Our ref: DOC19/54708

**NOTICE OF EXHIBITION FOR 85 HARRINGTON STREET AND 66-68 AND 70-72 GLOUCESTER STREET, THE ROCKS (SSD 7037 MOD 2)**

I refer to your email dated 21 January 2019 inviting comments on the above State Significant Development modification which includes: minor external and internal alterations to Block 1 and Block 2; alterations to Baker's Terrace; and alterations to access and landscaping, including removal of street trees and replacement planting.

Section / Elevation - Block 2 to Bakers Terrace

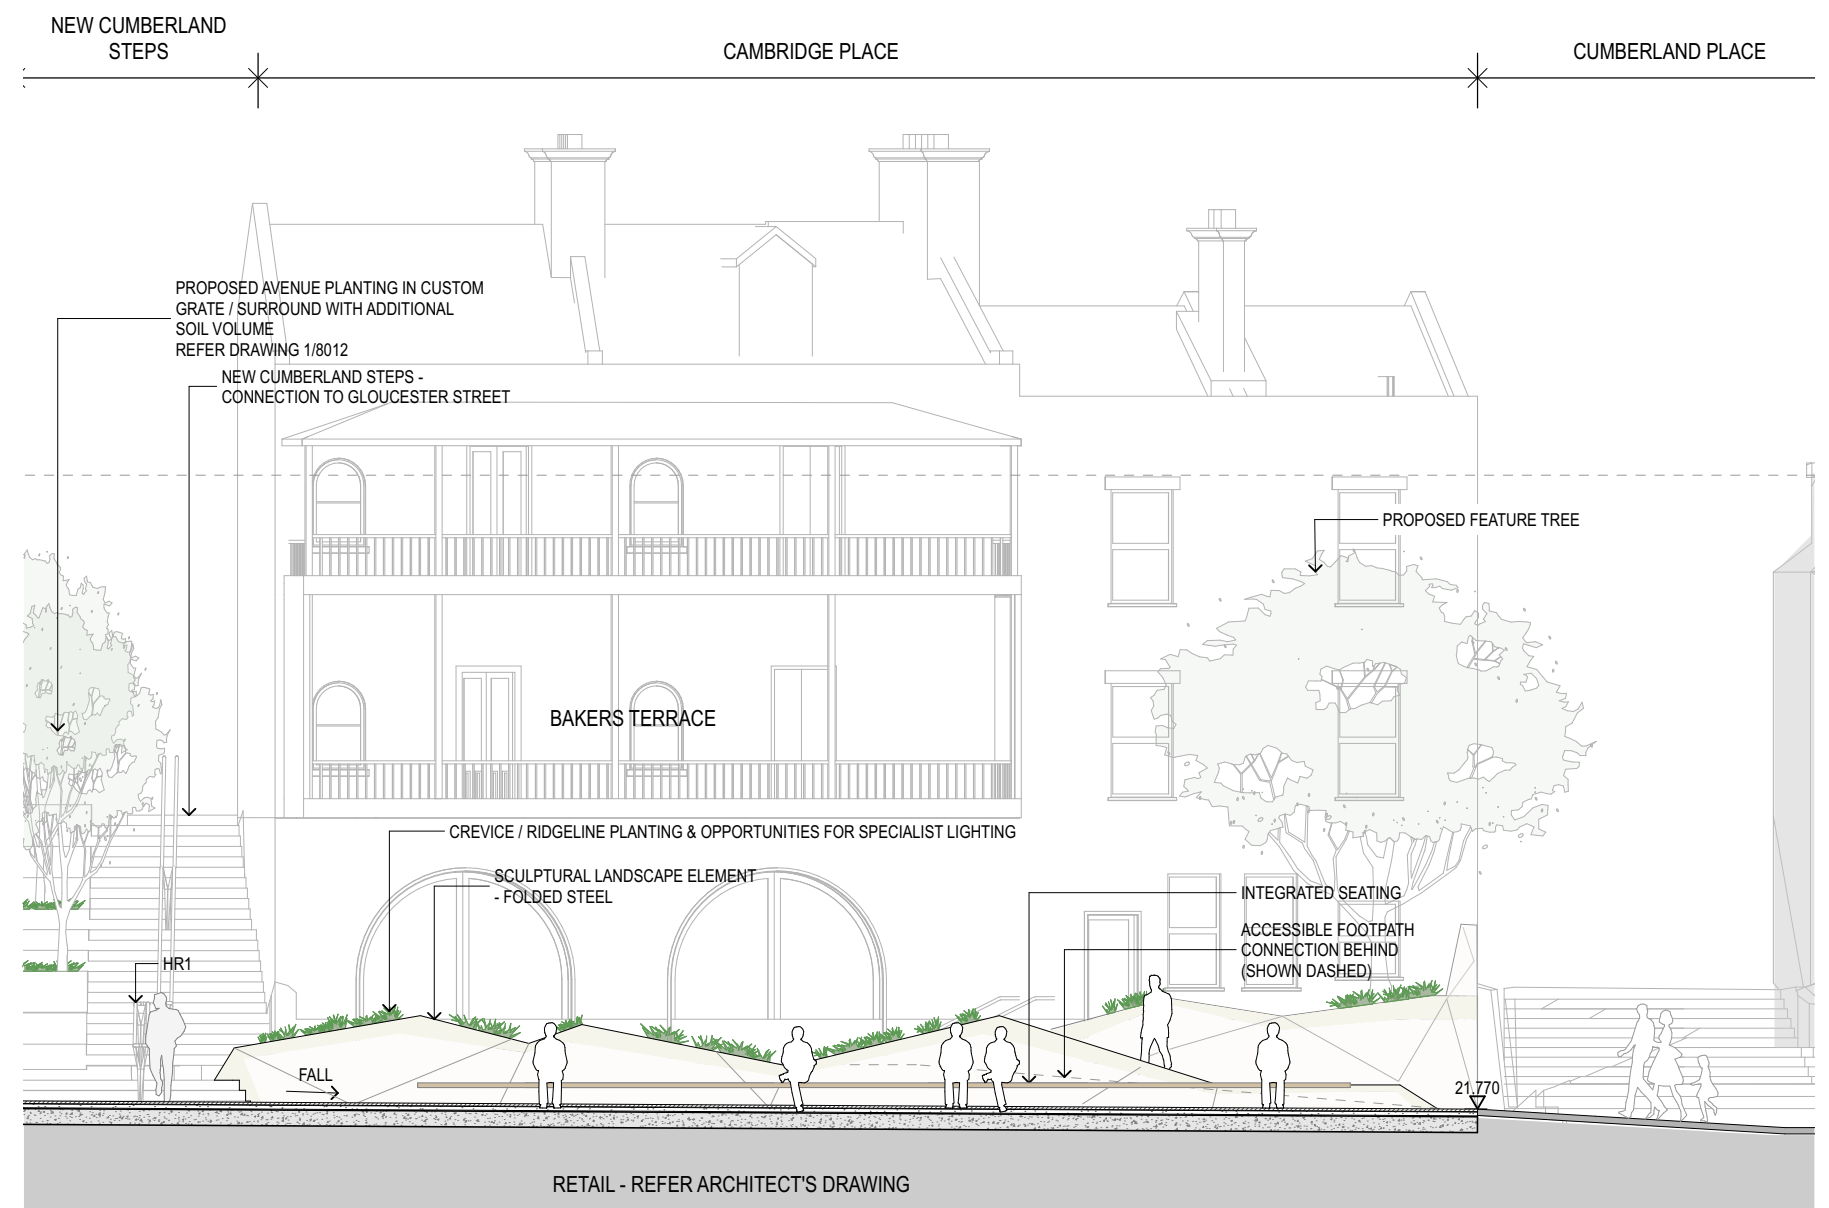
- The proposed landscape works between Baker's Terrace and Block 2 are supported as a modern, sculptural interpretation of the topography of The Rocks, with the differentiation in paving adjacent to Block 2 interpreting Cambridge Street. Consideration should be given to how this interpretation is conveyed to users as part of the interpretation strategy.

Being low in height the sculpture would not block important views to Baker's Terrace, or impact significant fabric or other important values and is acceptable. The retention of the Harrington Street ridge bedrock is a positive conservation action that is supported.

1 SECTION / ELEVATION Section Elev Bakers
1:100

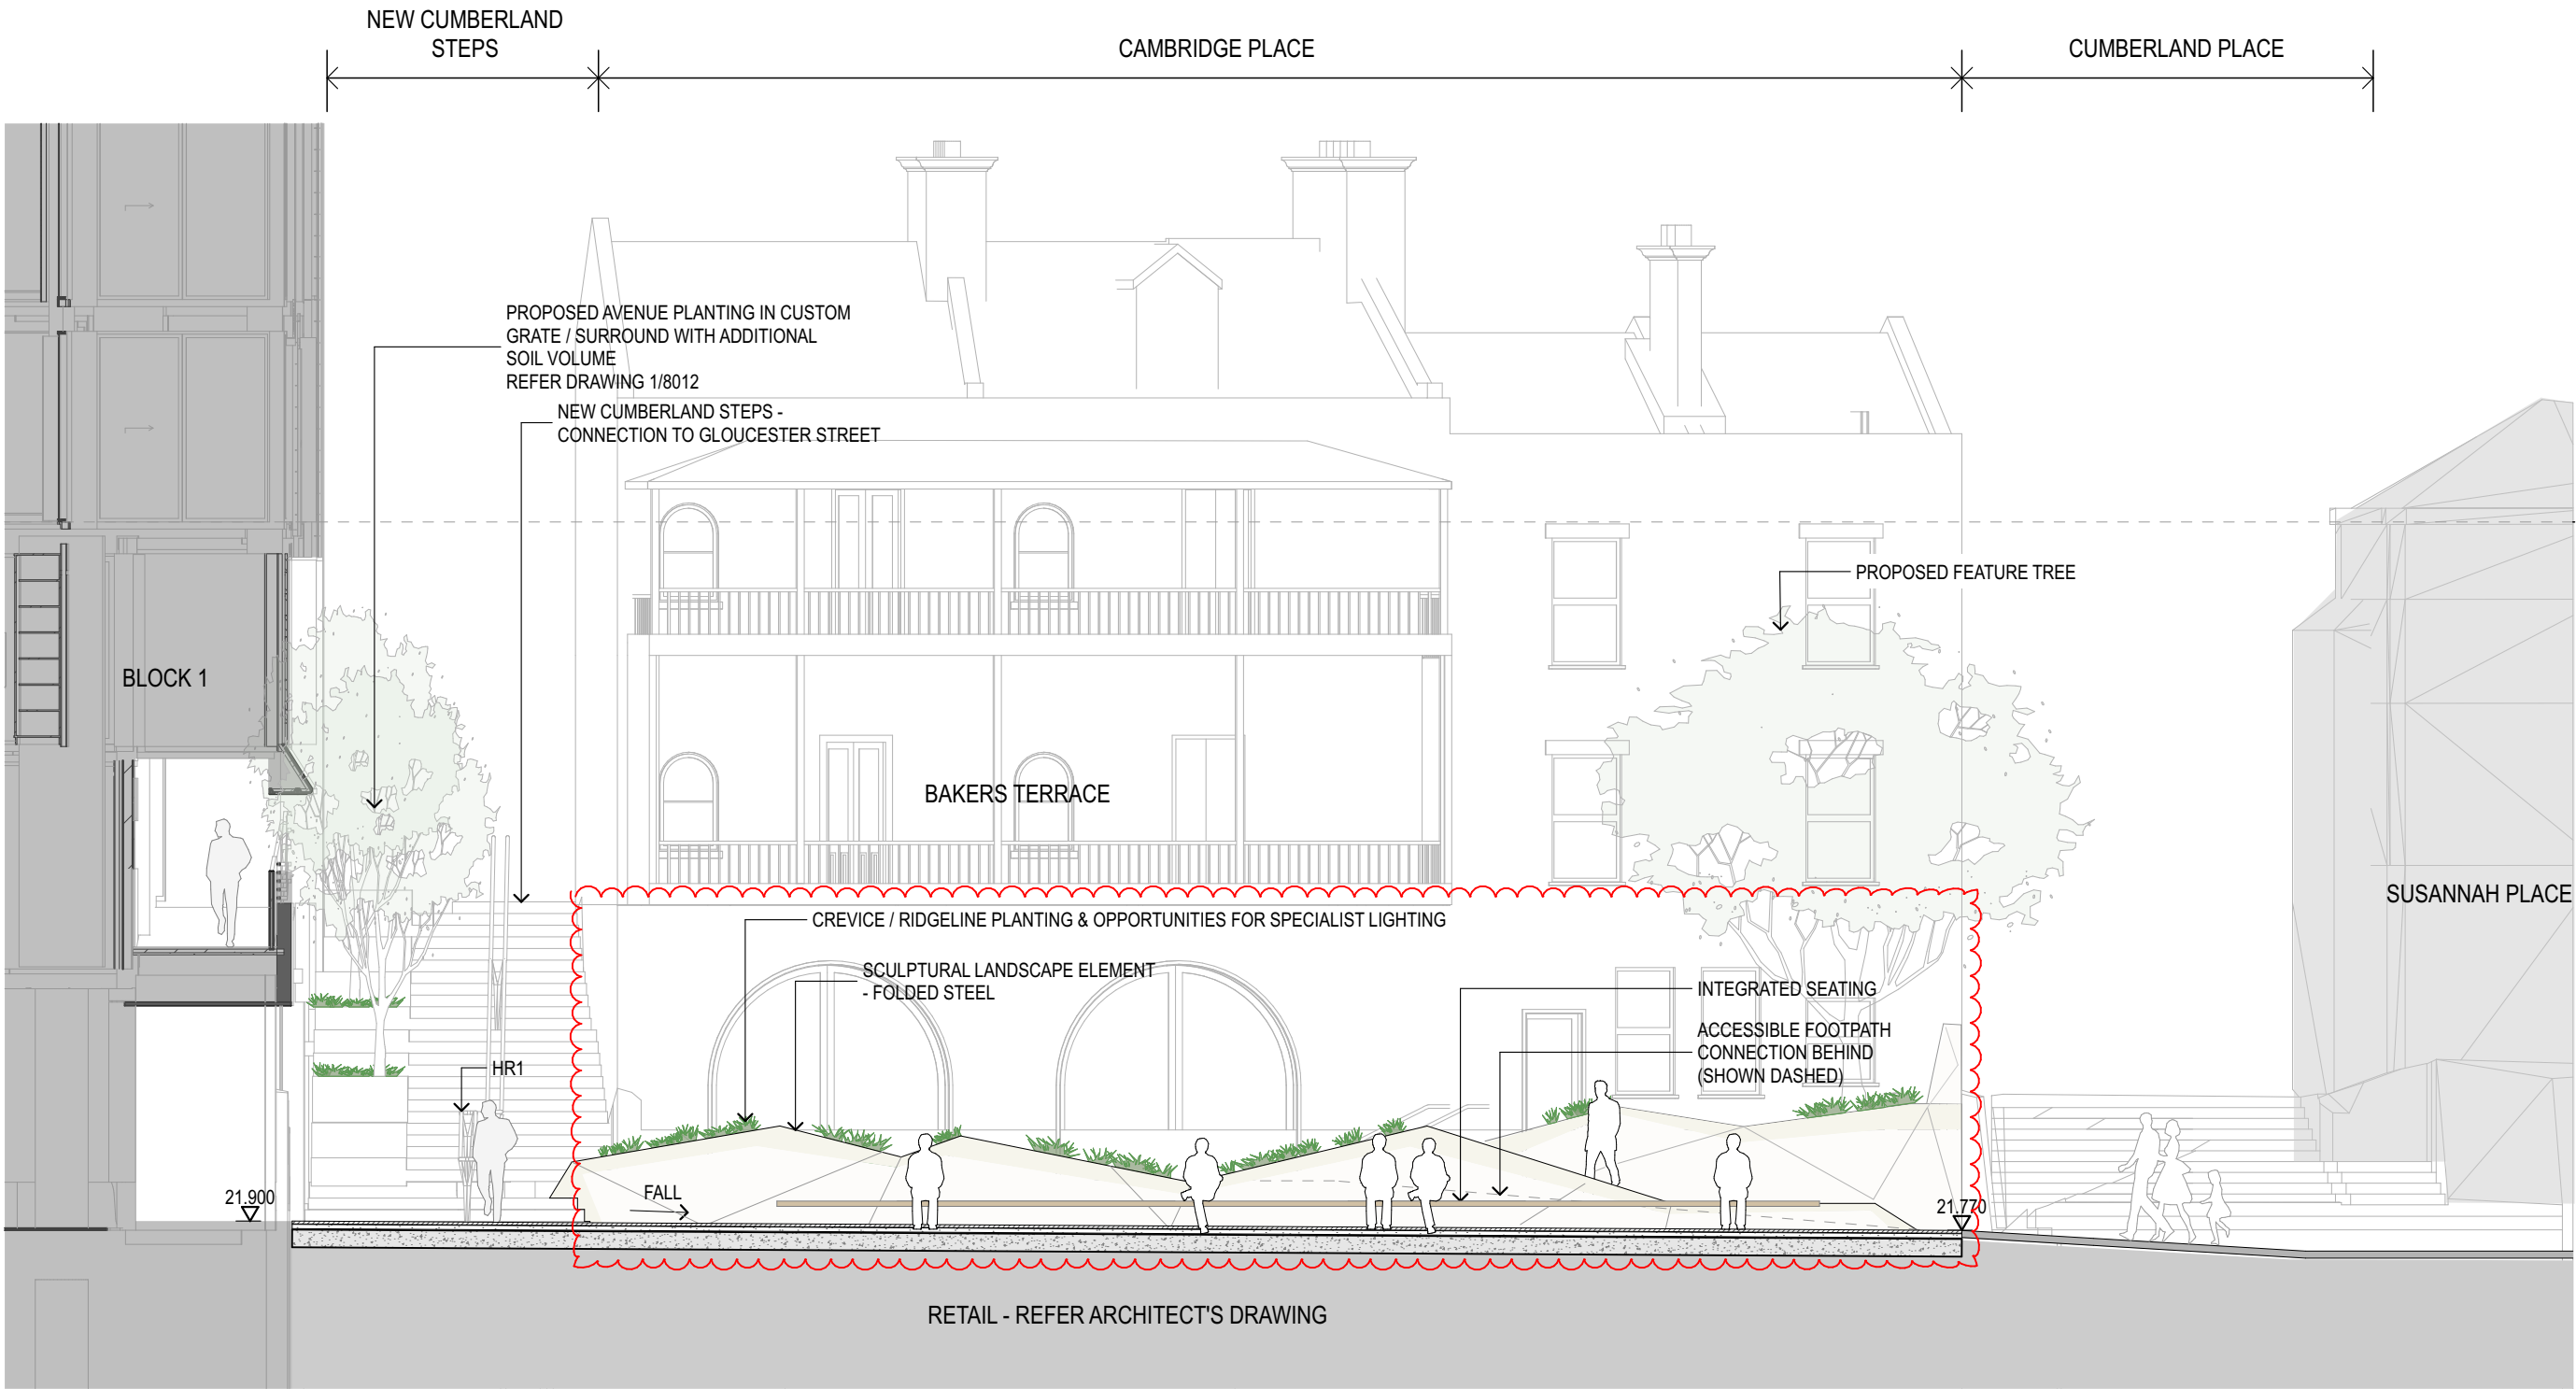
- Generally, the changes to Baker's Terrace are internal and retain more significant fabric than the original proposal. Whilst the changes to the floor level to the two front bedrooms of the northern terrace would have a minor impact on the spatial qualities of the rooms, the floating floor and step would be reversible and would not impact the significant heritage values of the terraces and is acceptable. The retention of fabric of high and exceptional significance in the basement addresses the condition previously recommended for the conservation of this fabric and is supported. The external presentation of the item would be conserved, ensuring the aesthetic values, views and contribution to the character of The Rocks would be retained.
